## **Great North Road Solar and Biodiversity Park**

S51 and S55 Responses Cover Letter

Document Reference – EN010162/APP/1.1A

**Application by Elements Green Trent Limited: Great North Road Solar and Biodiversity Park (Application Reference: EN010162)**

Drawing Title:
Statutory and Non-Statutory Features of Historic Environment Plan
SHEET 5 of 39

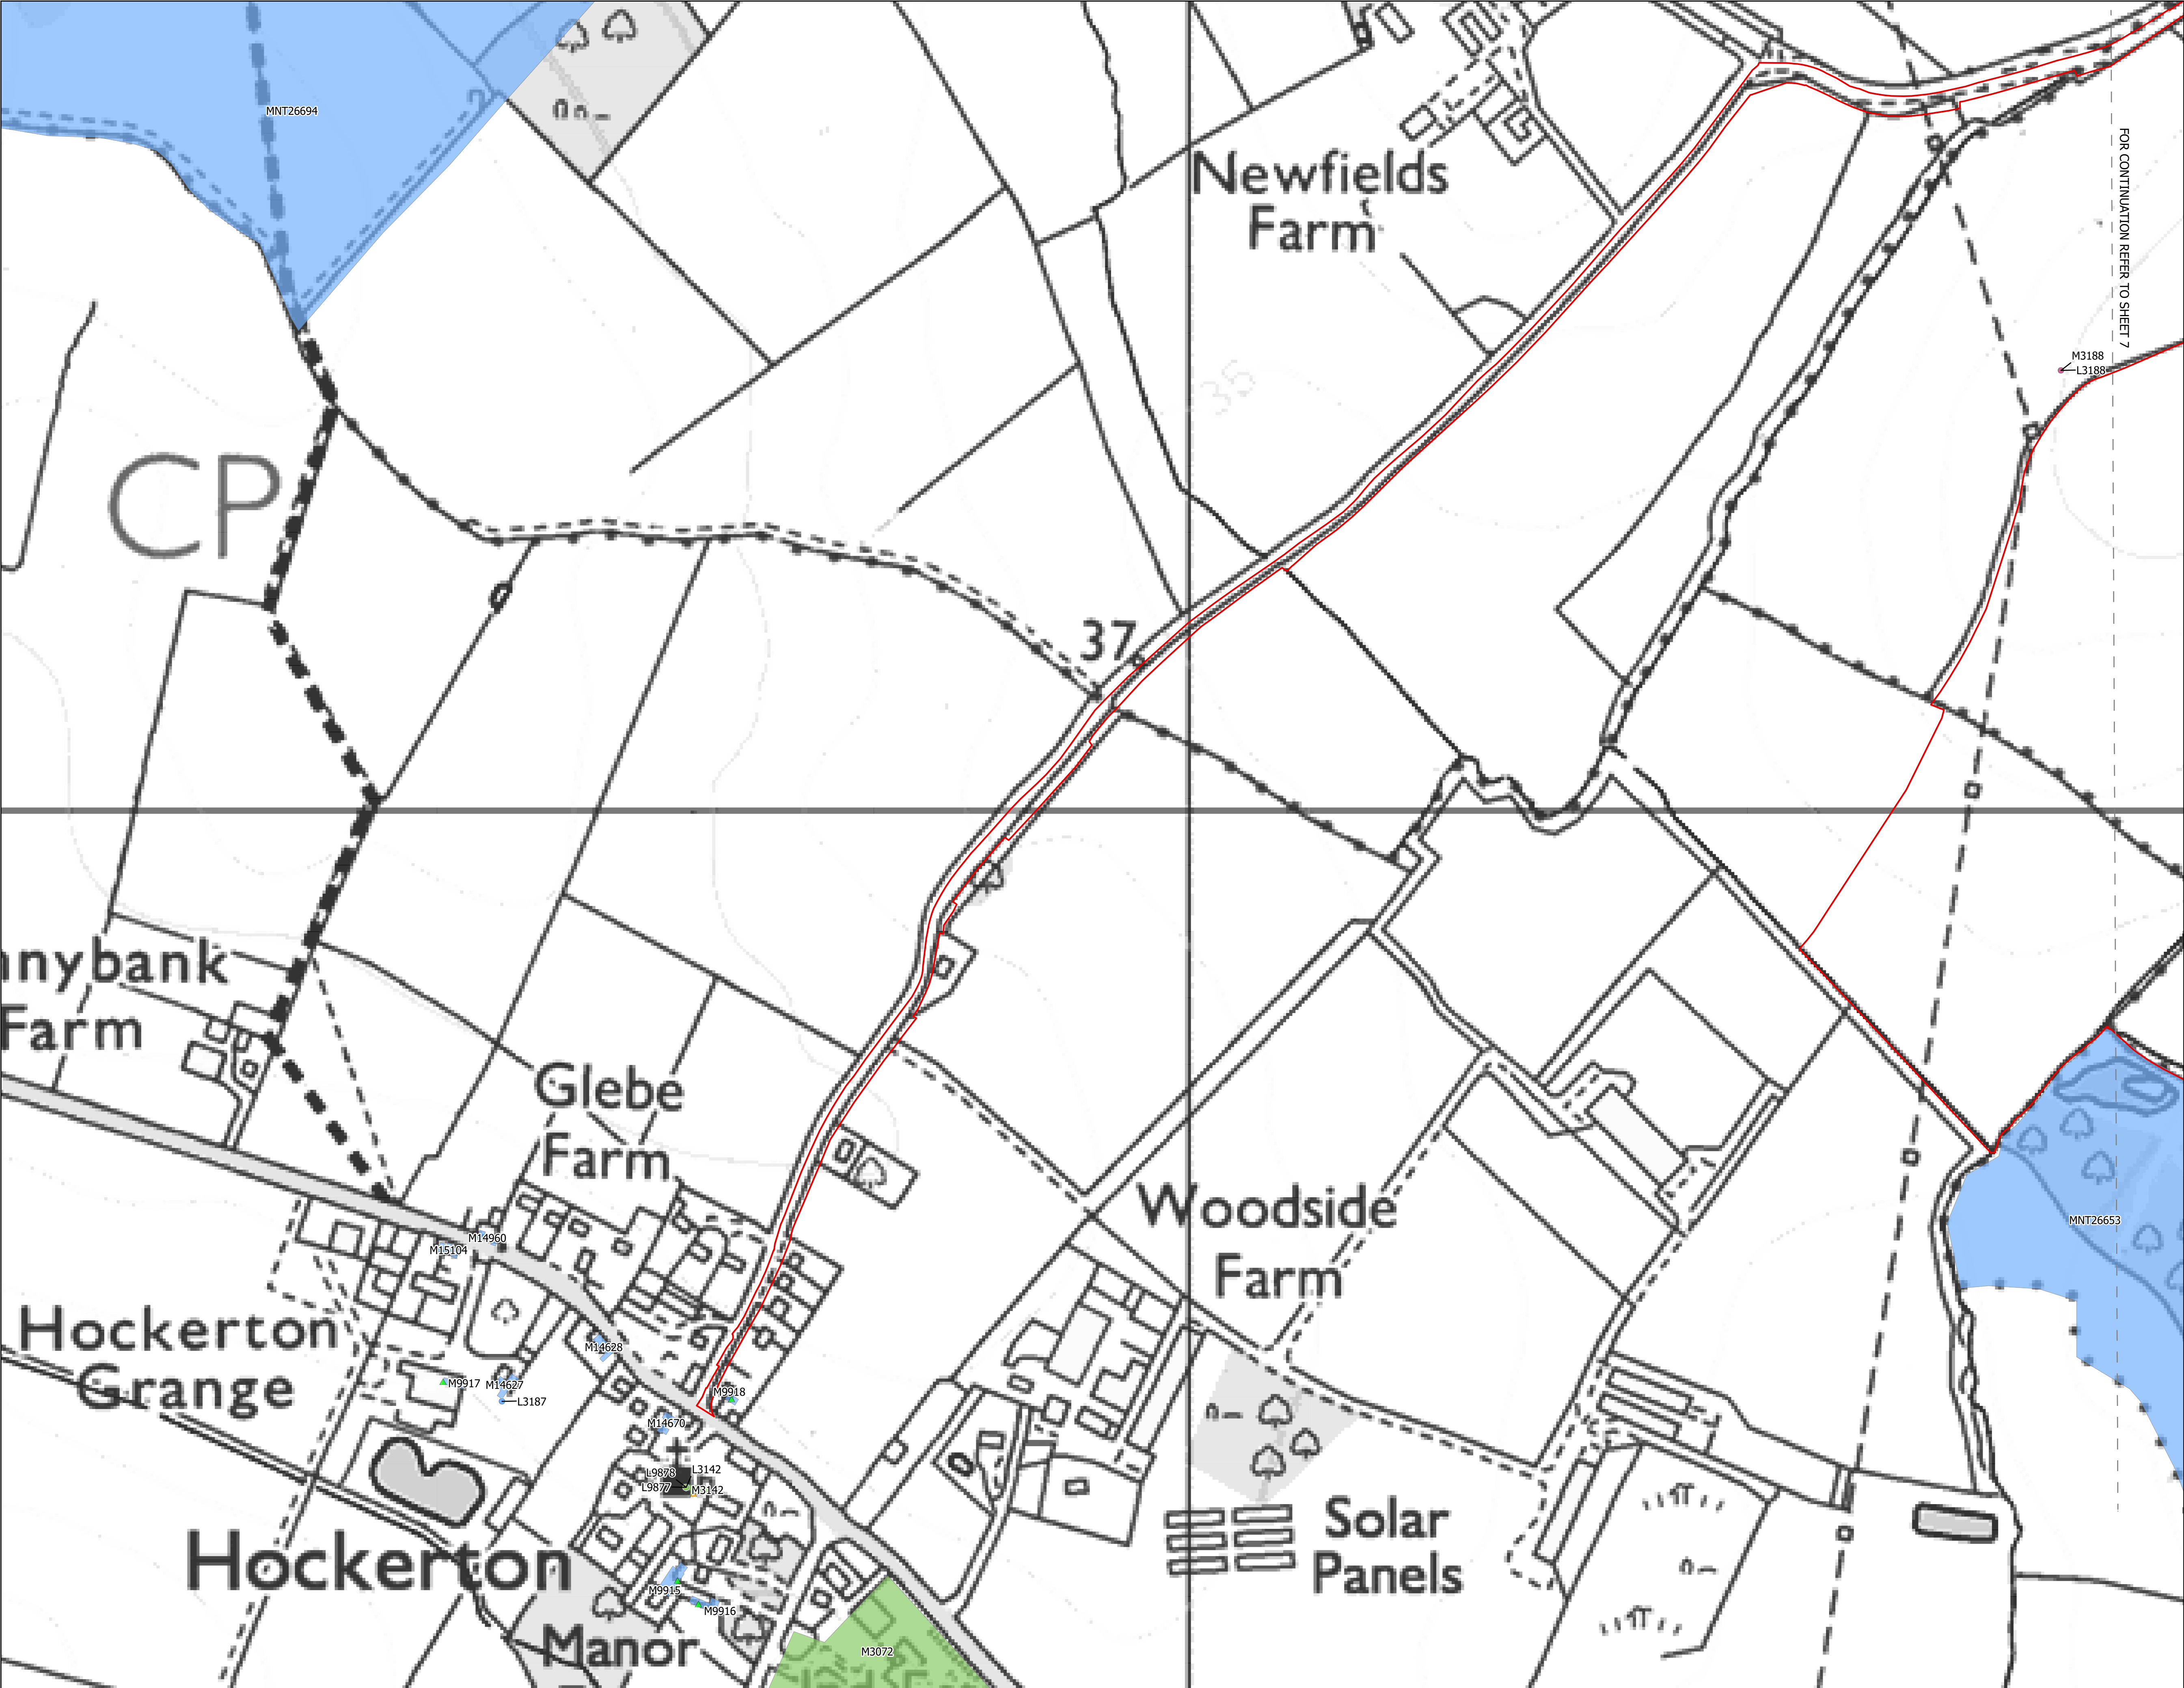
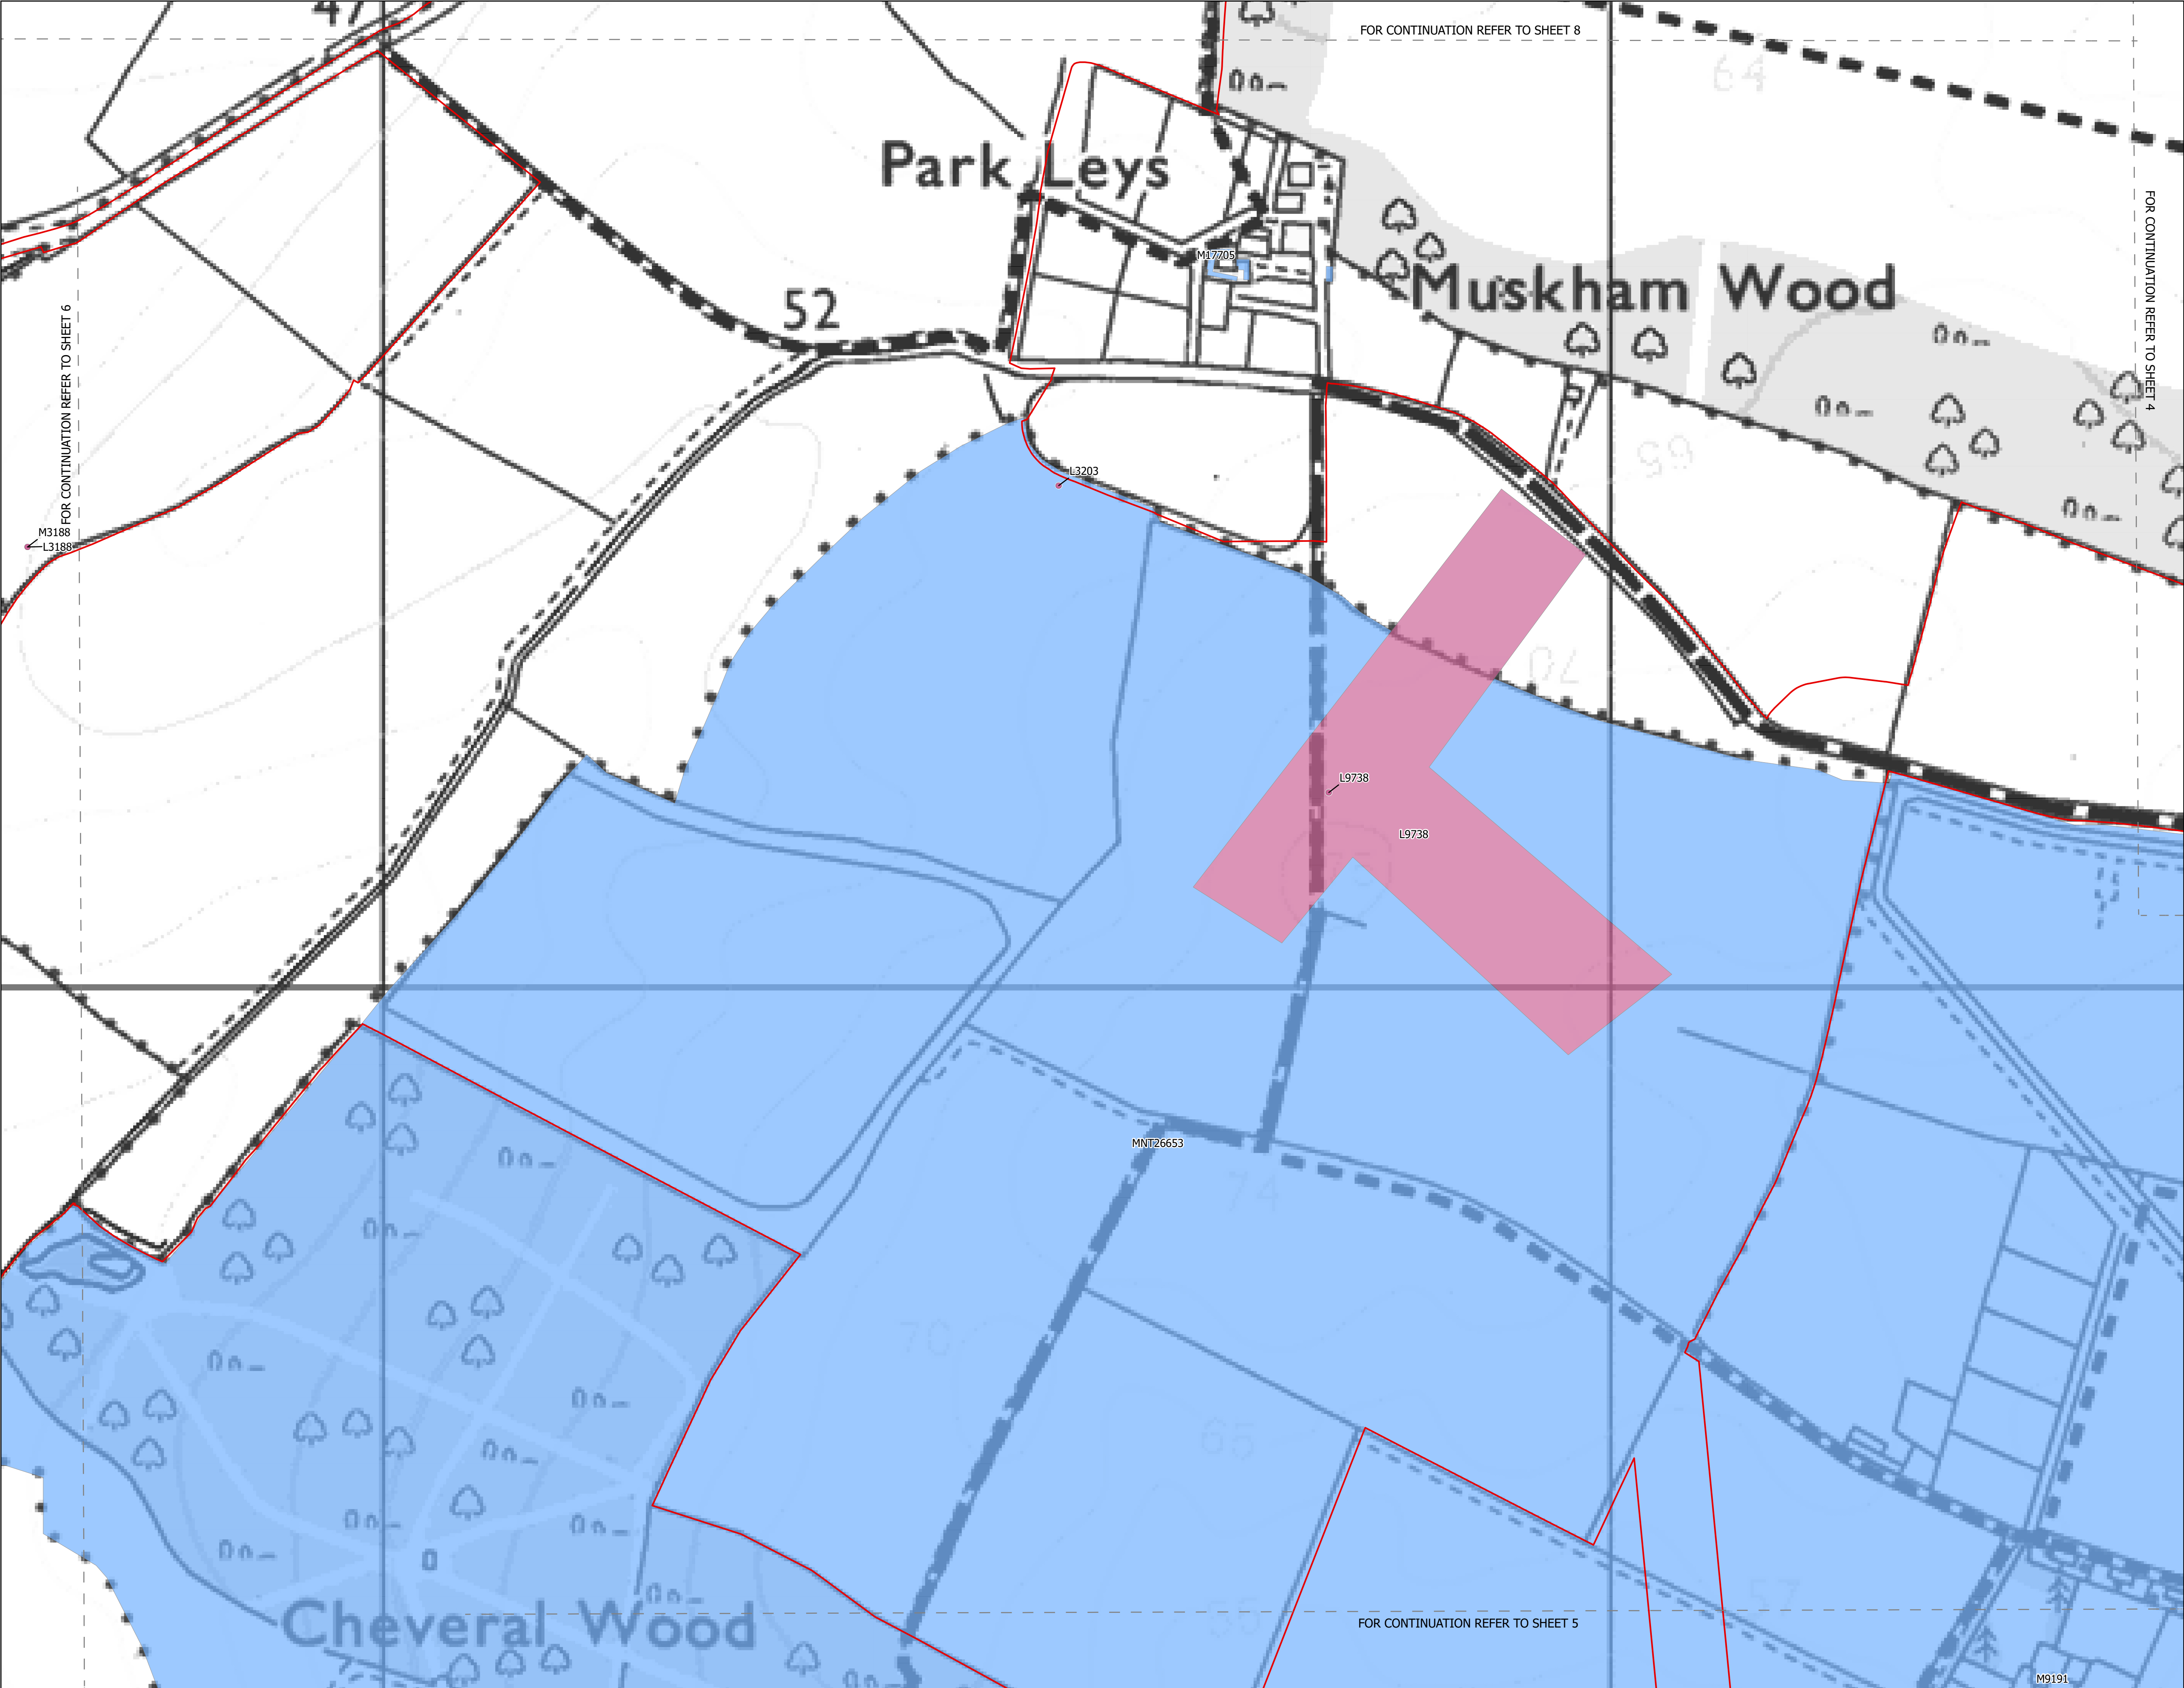
The applicant is advised to review these figures for clarity, specifically relating to the following points:

- due to the scale of the icons used and similar colouring, it is difficult to differentiate between Historic Environment Record (HER) assets and listed buildings/ grades
- a very similar colouring scheme between HER recorded 'undated' period and scheduled monuments keys has been used
- due to the small scale of the icons, the labelling sometimes obscures the record being shown.

An updated **Statutory and non-statutory features of Historic Environment Plan [EN010162/APP/2.15A]** has been submitted. The icons used on the plans have been updated to be clearer, along with a clearer differentiation between the colours used, and a clearer basemap.
